RE: MP 08_0250 MOD 1 – Modification to Project Application- Hunter Medical Research Institute (Part3AMod) – Finalised Response.

HMRI has now finalised responses to Newcastle City Council (NCC) concerns initially raised in NCC document Ref PB2016/09668 dated 20 October 2016 which could not be adequately addressed until the Plans of subdivision were amended by Cadence Consulting Surveyors.

Fig 1: Plan of Subdivision Document Ref CRH12-354C_DP_2A.pdf. This extract from the plan of subdivision whilst not appended to the NCC comments, has been included to aid in understanding of the ZHMRI response to the comment.

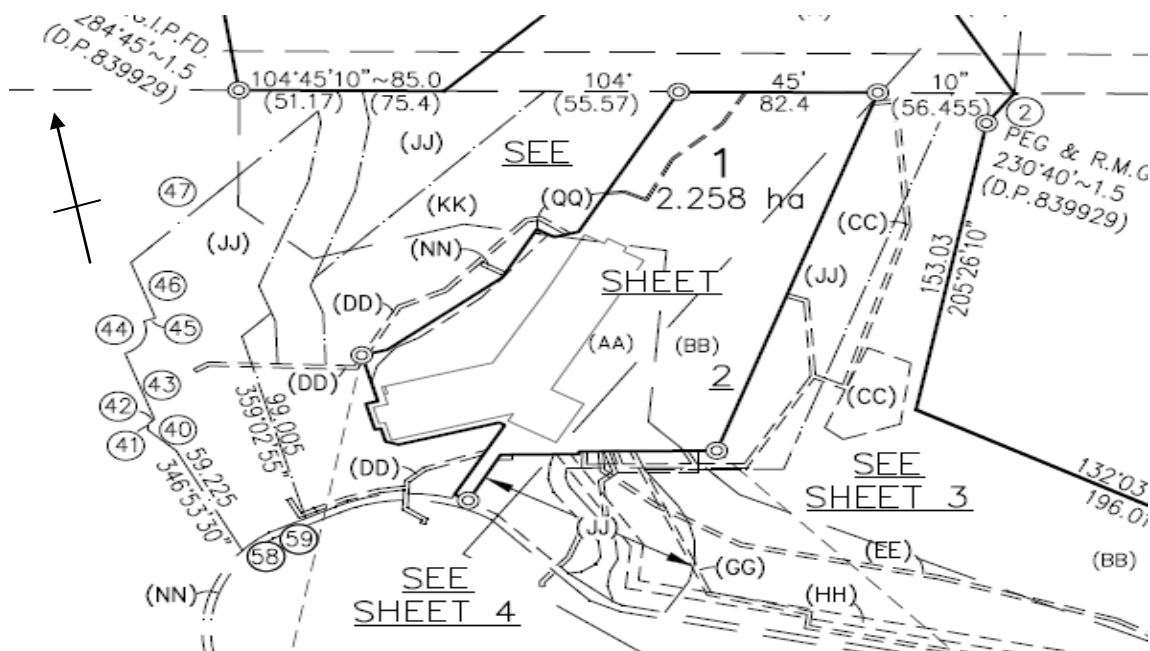
Comment 5 – That part of the land shown burdened by easement (JJ) Outer Protection Zone to the east of proposed Lot 1 should be notated as (KK) Inner Protection Zone is ^(sic) to comply with the Statement of Commitment 7.4 Bushfire – Recommendation 2 (See Appendix B of the Project Approval)

HMRI Response – Cadence Consulting Surveyors have corrected the issues with the definition of the extent of both (JJ) and (KK) generally and specifically corrected the Eastern extent of (KK), restoring it to harmonisation with the Australian Bush Fire Prevention Planners (ABPP) report No. B131943 dated 1/05/2013. We note that this is the latest version of the report. We further note that we have clarified in writing that Graham Swain the author of the report B131943 is satisfied that the representation of the zones in the proposed plans of subdivision Doc Ref CCS-1349_DP_2C_P(003).pdf meet his requirements as set out in that report.

Fig 6. Conditions of Consent Drawing K1002 - key Drawing Access & Movement Pedestrian & Bicycle Movement

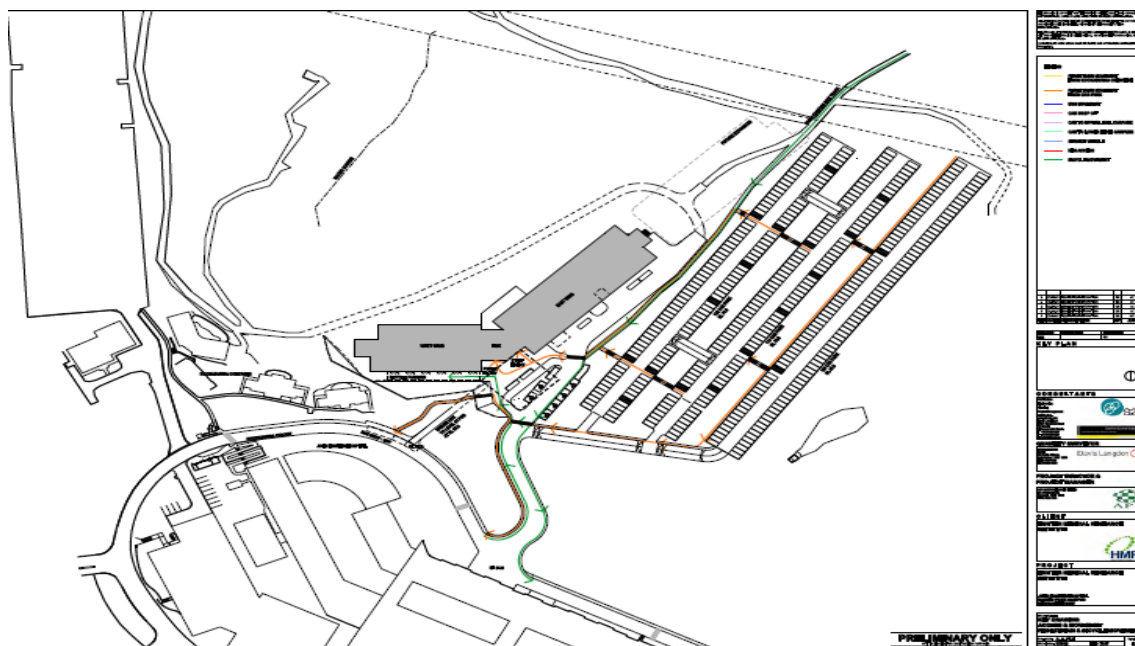
Comment 8 – The shared pathway entering proposed Lot 1 from the bushland to the North appears to be at least 2.5m wide, however proposed Easement (QQ) is noted as a Right of Footway 1m wide and variable. It is also apparent from arial photographs that the shared path provision extends further south than as depicted in the draft DP. The easement should be amended wholly to contain this pathway. Consideration should also be given as to who is to have benefit of this easement as members of the public might use this pathway to access the wider HNEH campus.

HMRI Comment – Sheet 1 to 4 of the Plan of Subdivision identify the following Easements including lots burdened and benefited, and should address the concerns raised by Council :

- **Easement (VV) [Right of cycleway]** links with the end of the Jesmond Cycleway/Walkway and traverses Easement (A) [Easement for electricity transmission lines and access]. This joins seamlessly with;
- **Easement (YY) [right of carriageway 4 wide and variable width]**. This joins seamlessly with;
- **Easement (NN) [Right of carriageway 3.5, 7 wide and variable width]** which forms a contiguous link to the perimeter road network of the John Hunter Hospital

We take the view that the easements created provide a flexible but adequate guarantee of access for cyclists and provides a deemed to satisfy outcome in keeping with :

Schedule 2, Part A – Administrative Condition Clause A2 states that “.. The Proponent shall carry out the project **generally in accordance** with the following plans documentation and recommendations ...” made therein. Specifically, Drawing K1002, Revision 5 Titled “Key Drawing Access & Movement Pedestrian & Bicycle Movement” dated 7/08/2009 and appended here below as Fig. 6, clearly supports a view that it was the intention of the Department when approving the development that there would be a direct linkage between the existing Jesmond shared bike and pedestrian Track and a path of travel through the HMRI site (see the green shaded flow through the drawing).
